**FALMOUTH PLANNING BOARD MEETING MINUTES
TUESDAY, AUGUST 7, 2012, 6:30 P.M.
FALMOUTH TOWN HALL, COUNCIL CHAMBERS**

4. TPO Properties, LLC – 26 LedgeWood Dr. – Request for sketch plan review of a proposed subdivision and request for waiver of requirement for joint meetings under 30-MRSA §4403. Tax Sheet 512; Map-lot R04-068-E. Zoned RA and RCZO.

**OLD BARN ESTATES**  
 1062 OCEAN AVENUE, PORTLAND, MAINE  
**POST DEVELOPMENT DRAINAGE PLAN**

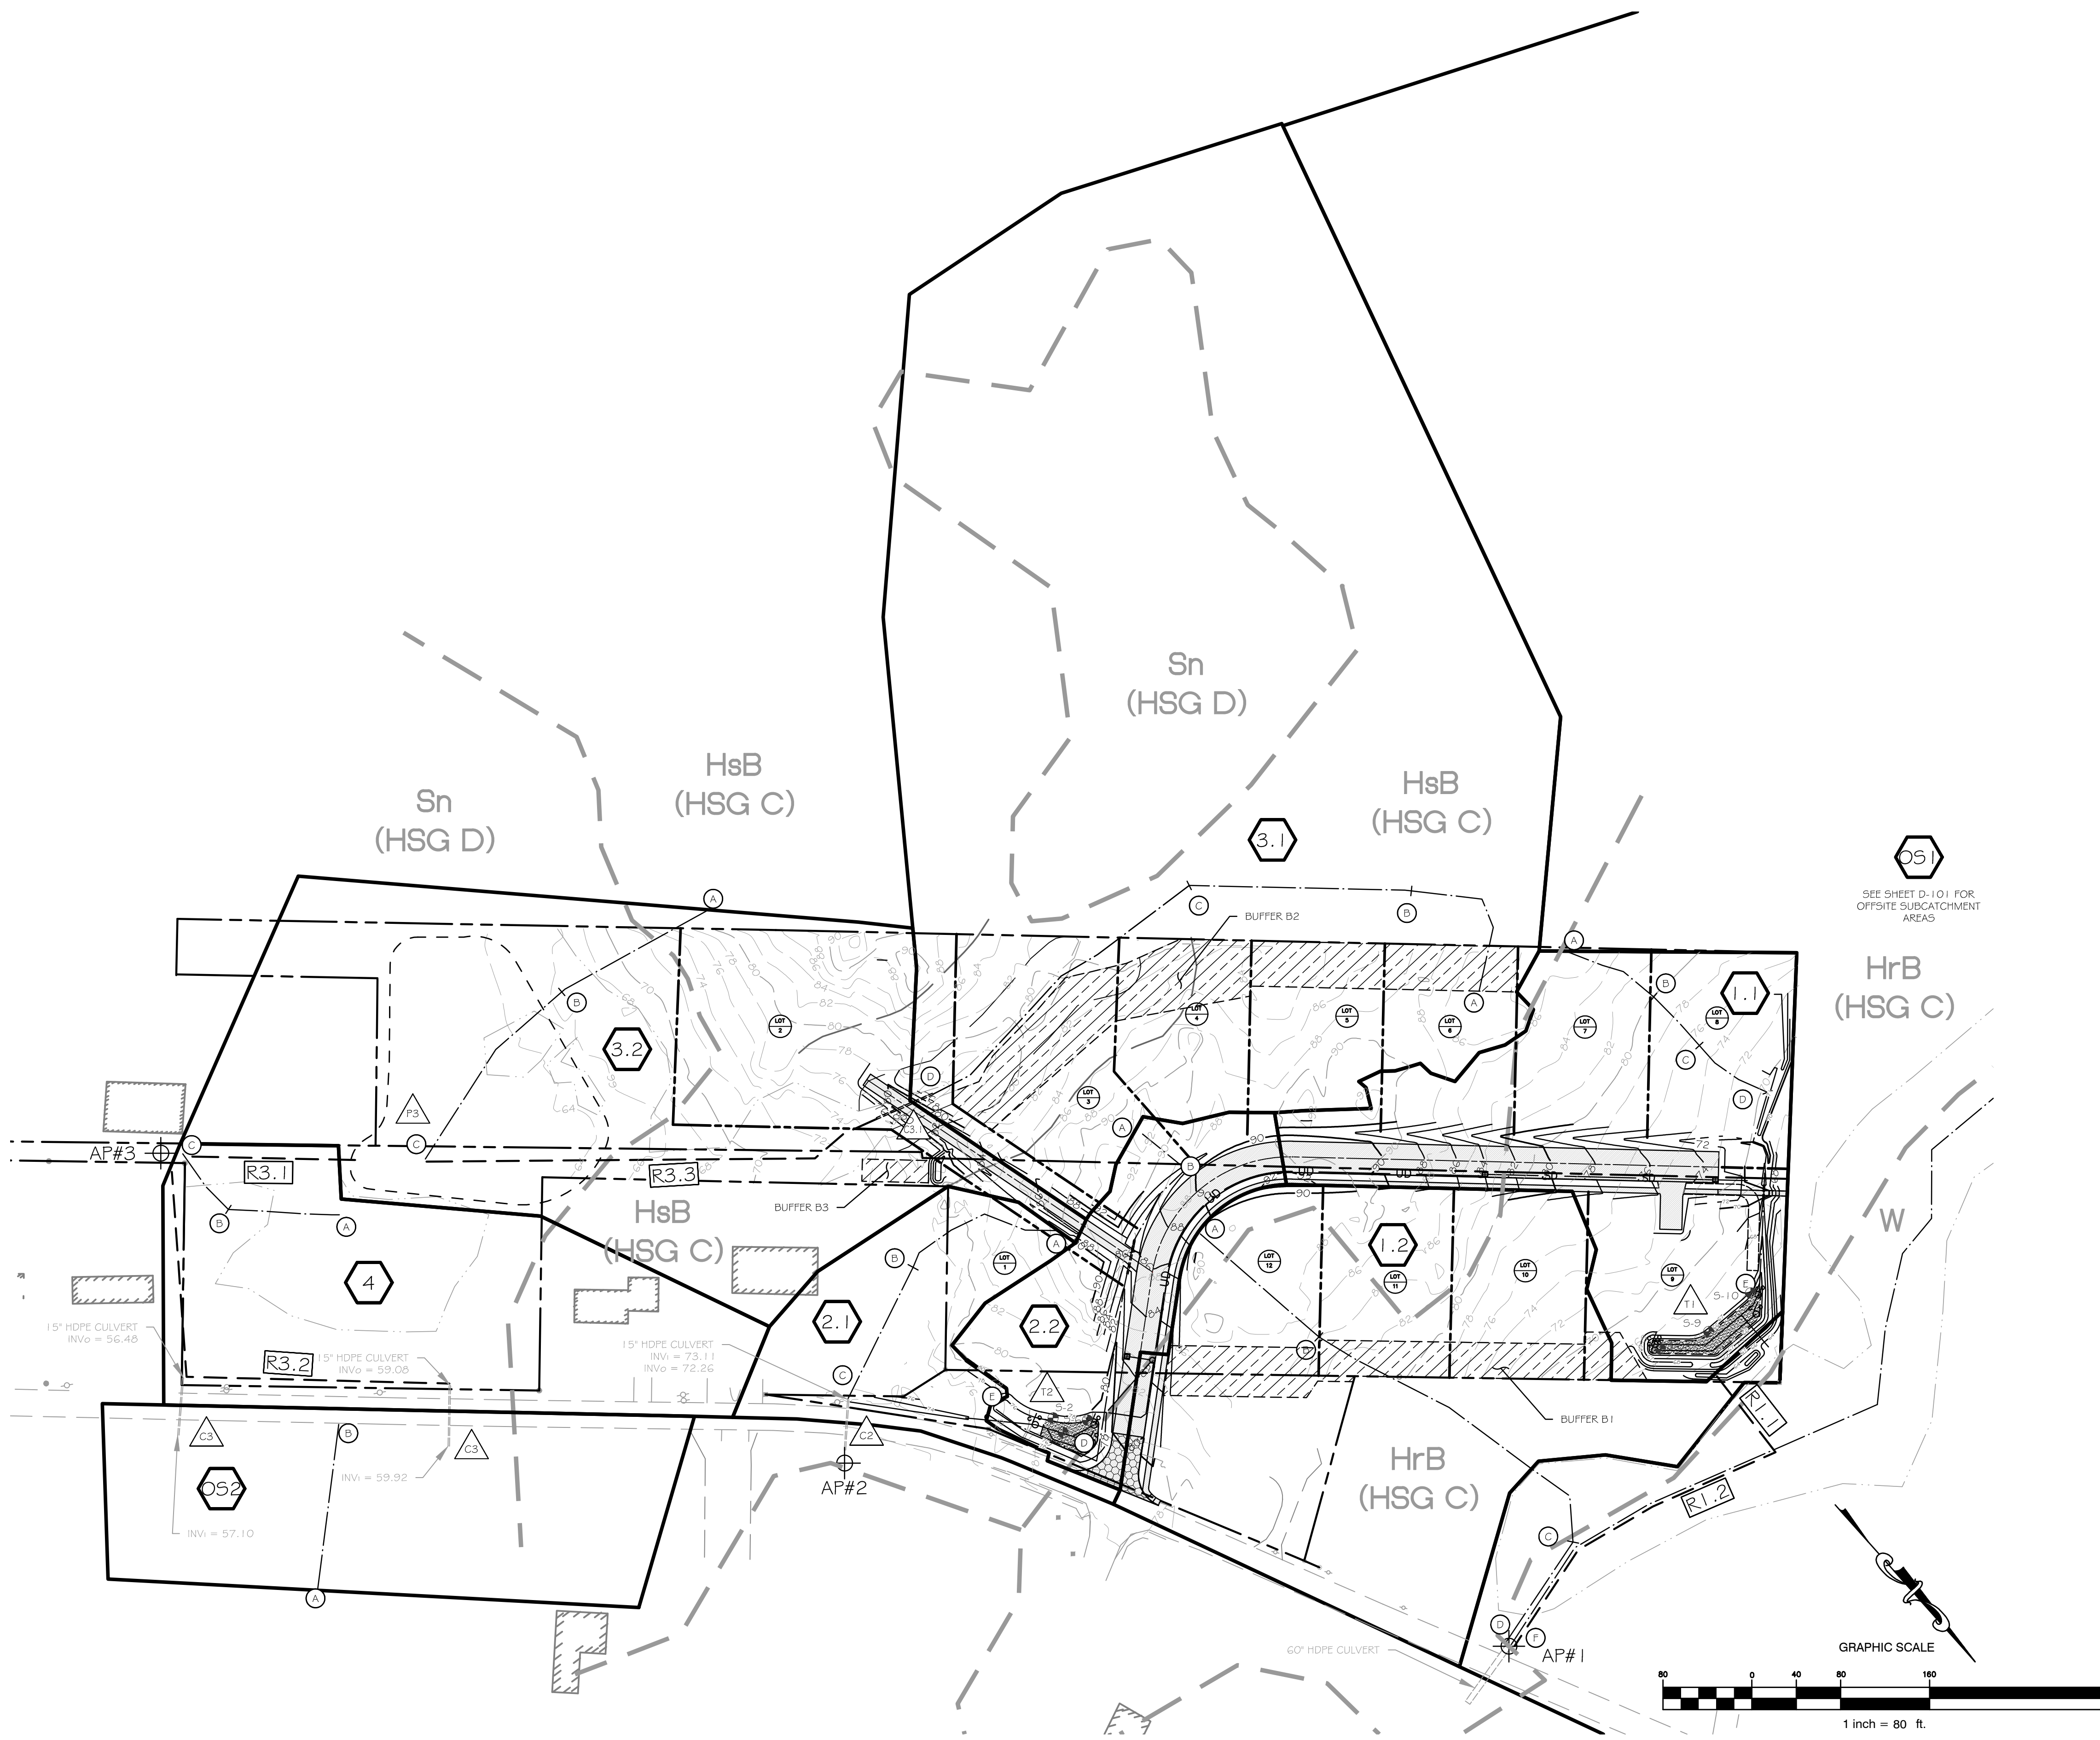
Bill Lunt was concerned about the storm water that will flow toward the Ledges; there is a brook there. Mr. Biegel thought there would be stormwater quality and detention there, as well as an easement.

Bill Lunt thought everything runs from this property to Ledgewood Drive.

Mr. Biegel said everything flows in to the wetland and then to Ledgewood. They will address this issue when they come back. He said lot 14, the lot in Falmouth, will still be a conforming lot after it is bisected by the road. The septic system will be relocated to the back, and the driveway will be relocated to the subdivision road.
